CITY OF ALBUQUERQUE

April 16, 2018

**Re: Constitution Site Planning
12000 Constitution Ave NE
Traffic Circulation Layout
Engineer's/Architect's Stamp 04-13-18 (J22-D069)**

1 Architectural Site Plan
Scale: 1"=10'-0"

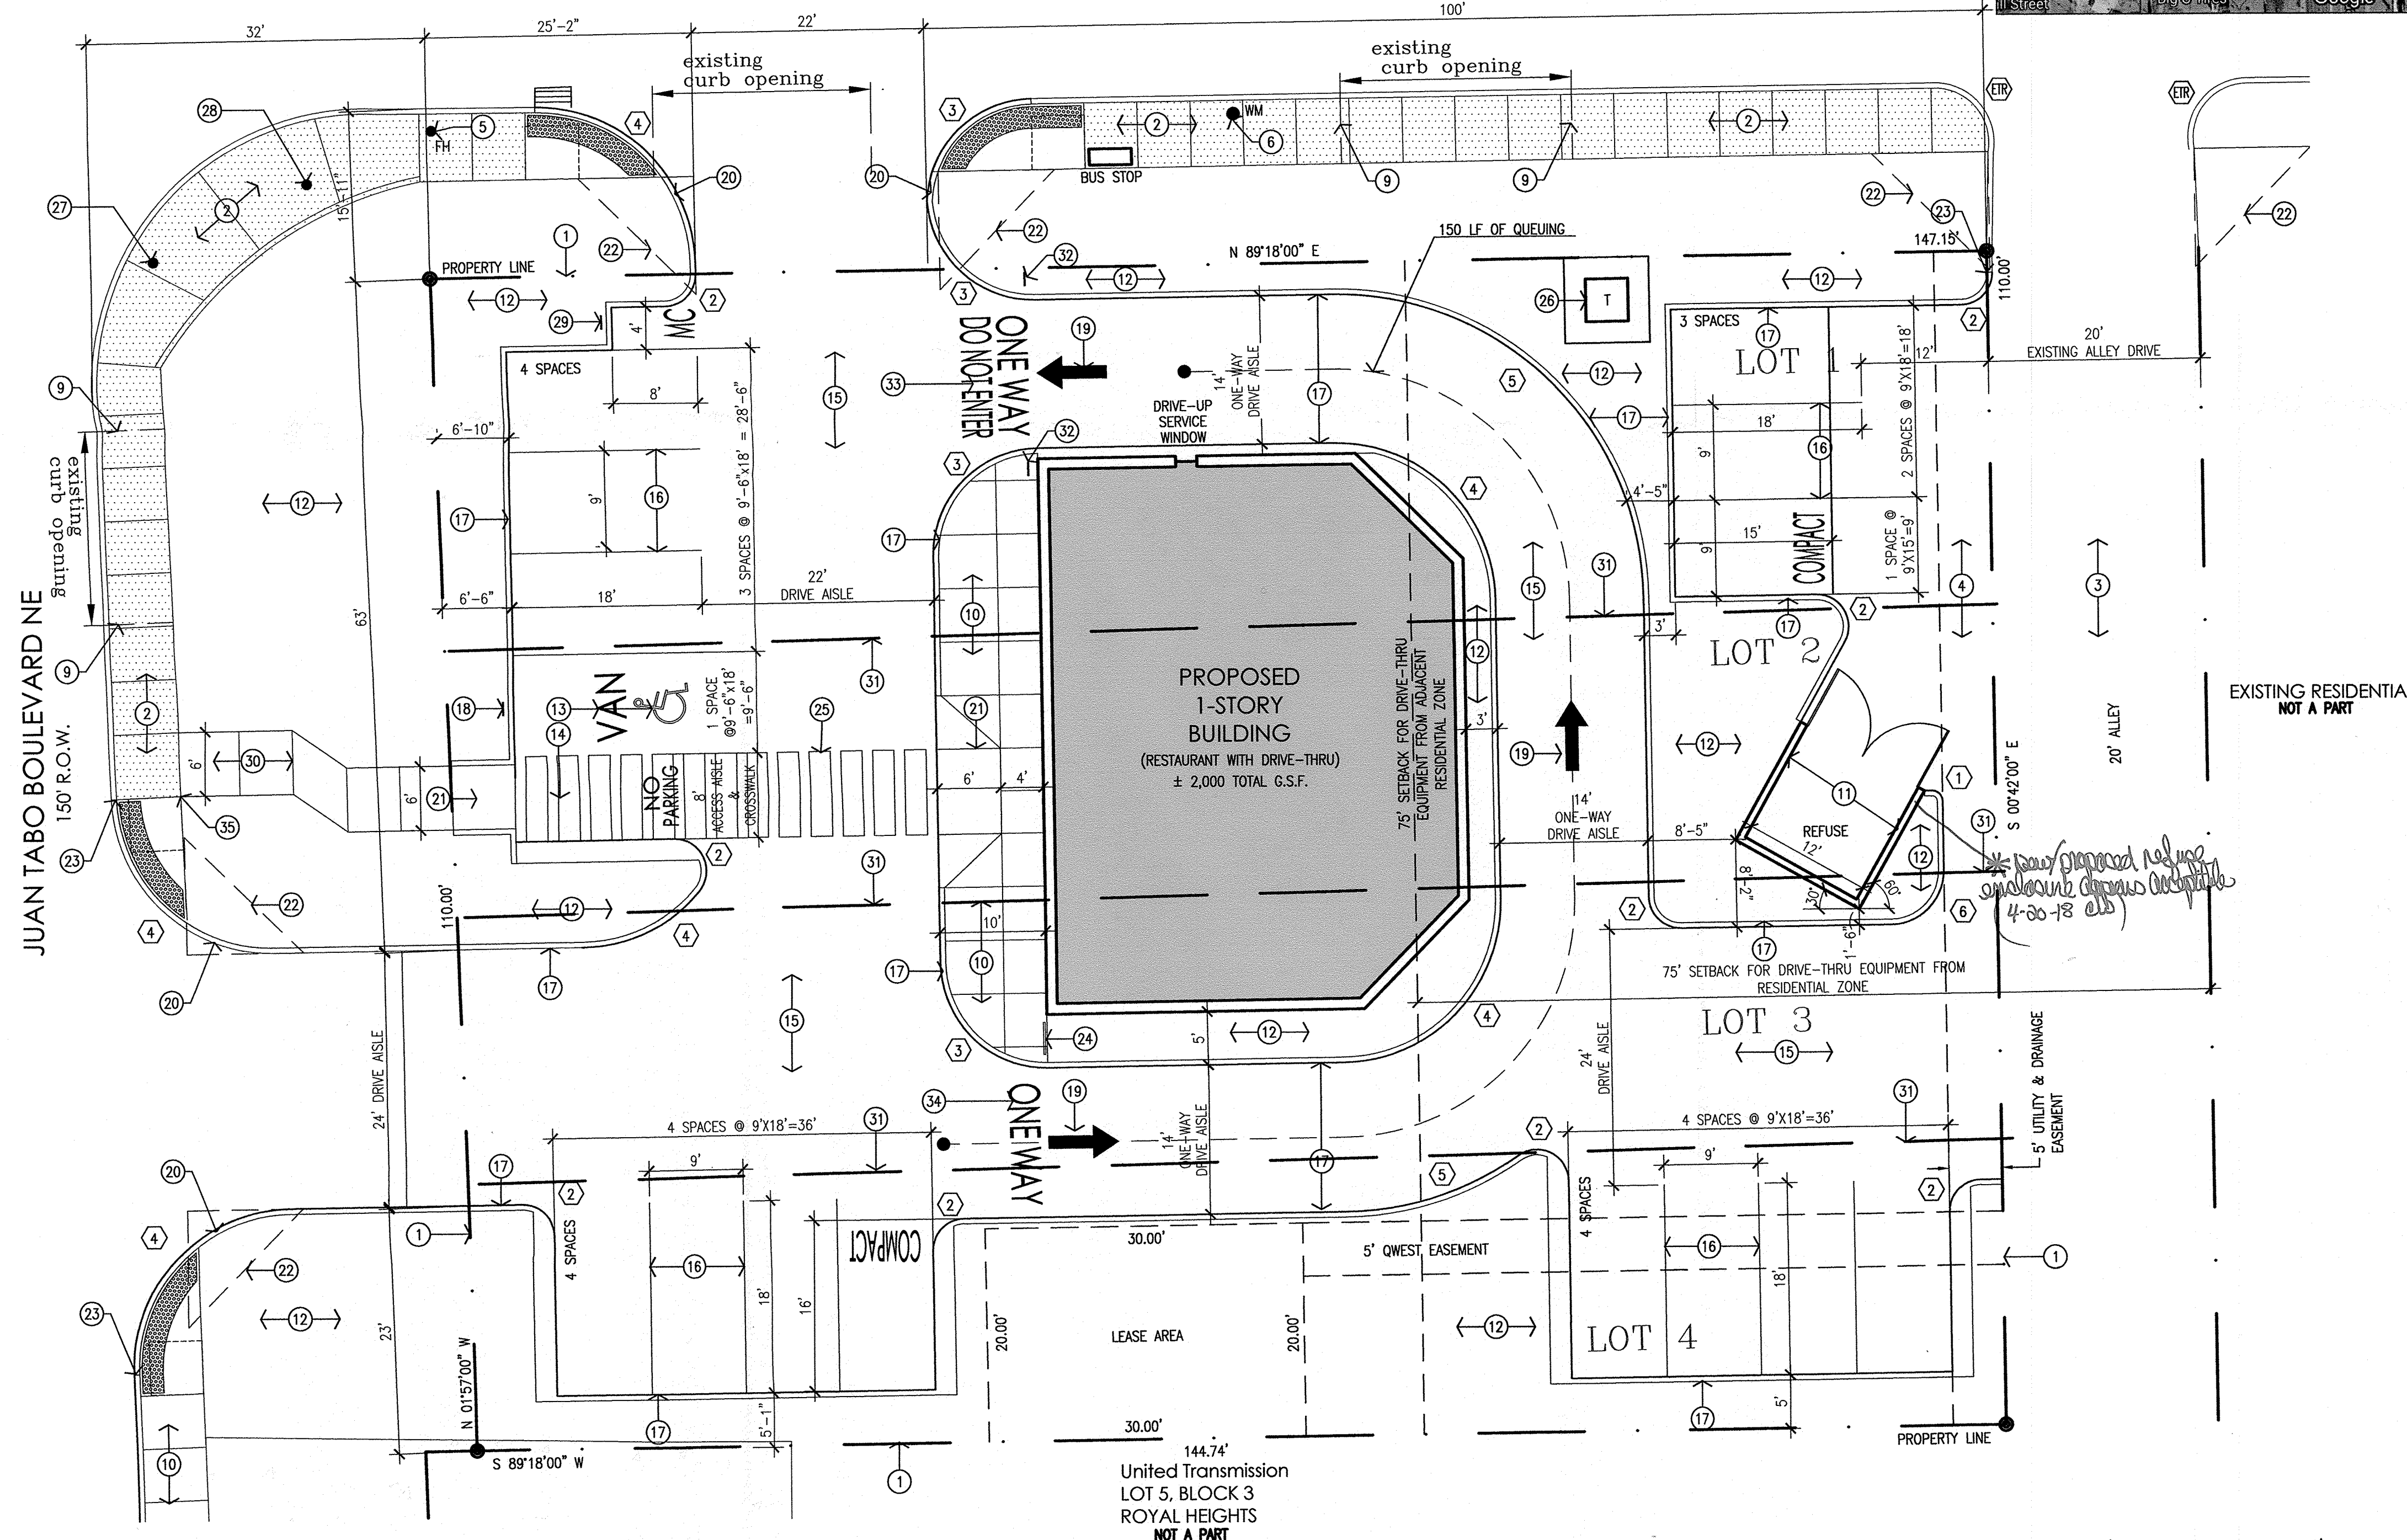
1. This site has multiple lot lines and may need to be replatted. Check with zoning if this is a requirement.
2. Drive aisles must be 24 feet for two-way travel unless the parking spaces are 9.5 feet wide, then it can be 22 feet.

3. Please show how the 6 foot pedestrian path to the building will work with the public sidewalk/curb ramp. The connection may need to be adjusted.
4. Service vehicle and/or refuse vehicle maneuvering must be contained on-site; provide a copy of refuse approval.

5. One-way vehicular paths require pavement directional signage and a posted "Do Not Enter" sign at the point of egress. Please show detail and location of posted signs.

6. Work within the public right of way requires a work order with DRC approved plans. The work in the Alley will require a city work order.
7. Please add a note on the plan stating "All improvements located in the Right of Way must be included on the City work order."
